ONLINE COMMENT ON PLANNING APPLICATION 23/11114

Location 12 ATHELING ROAD, HYTHE SO45 6BR

Objection received from Mr Alan Gaunt
4 Alexandra Close
Hythe
Southampton
SO45 6BB

Proposed FF Plan

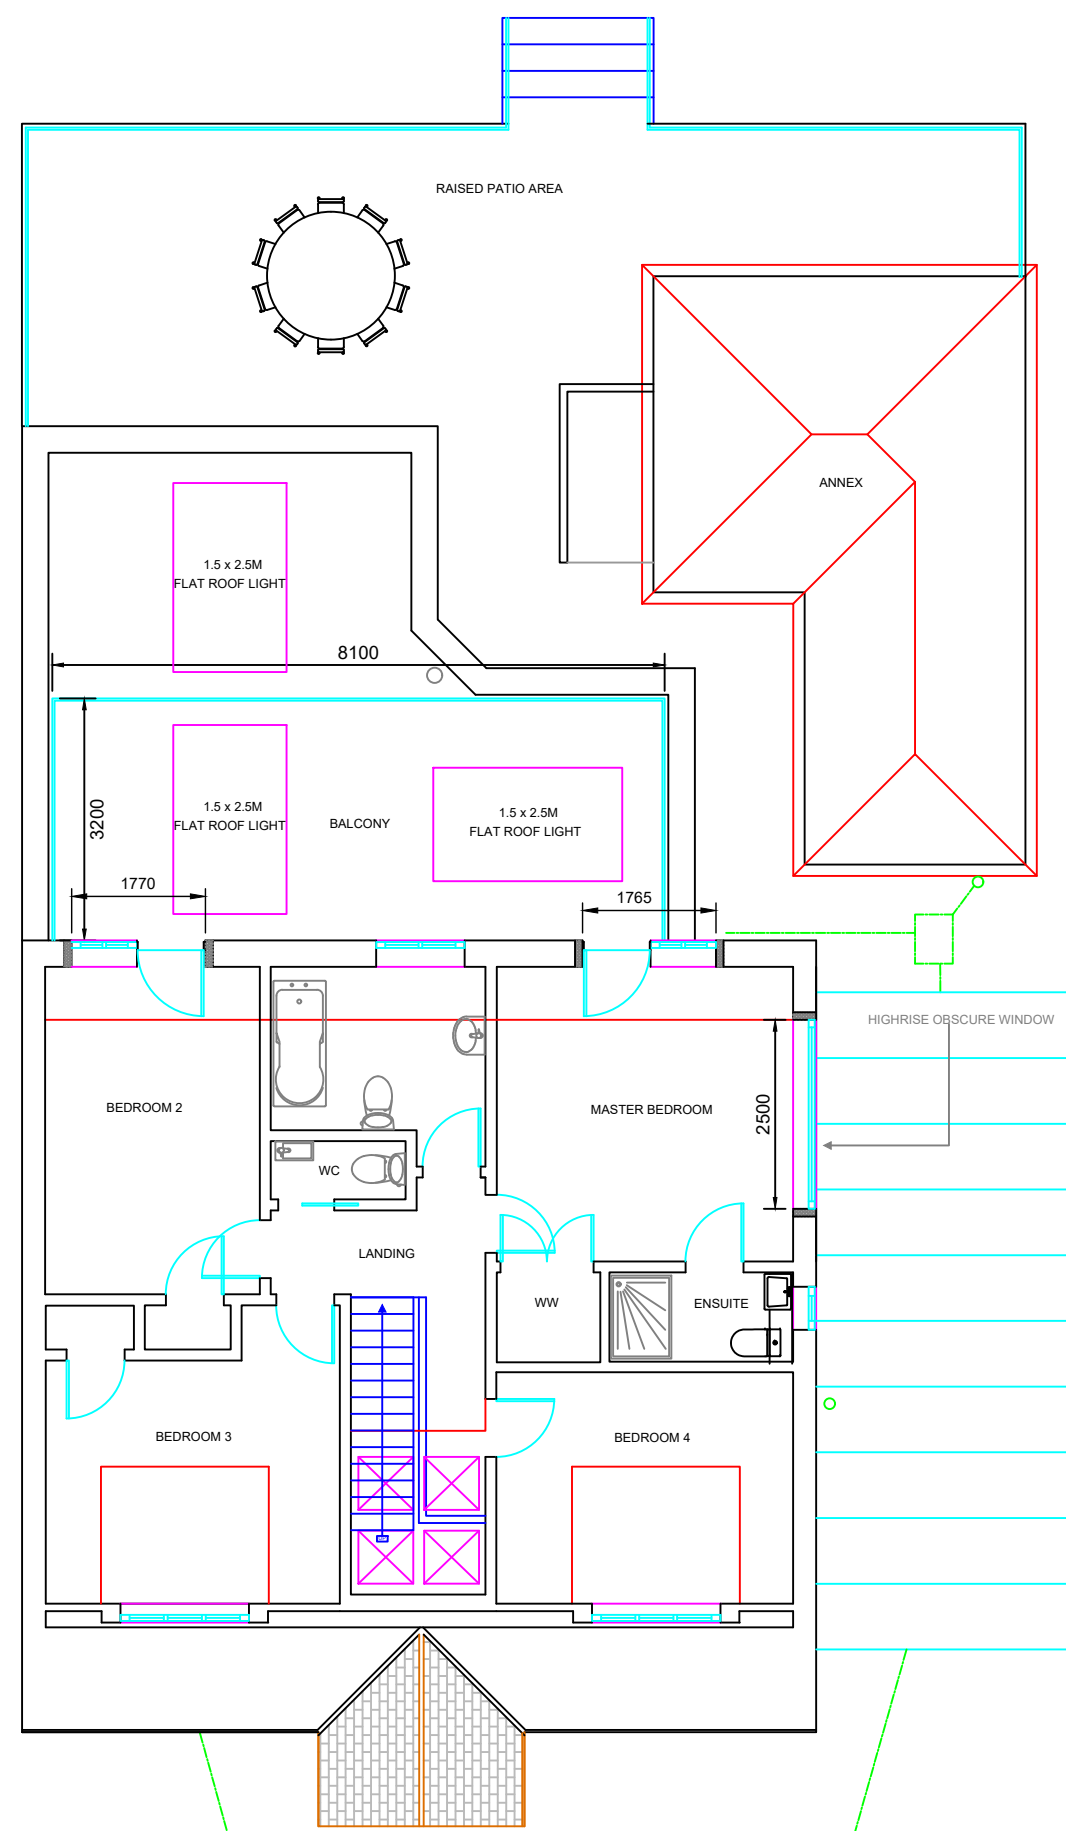
Comment: The proposal would increase still further, by the inclusion of a balcony and increase in glass doors to the rear of the property, the overlook of my property and loss of privacy.
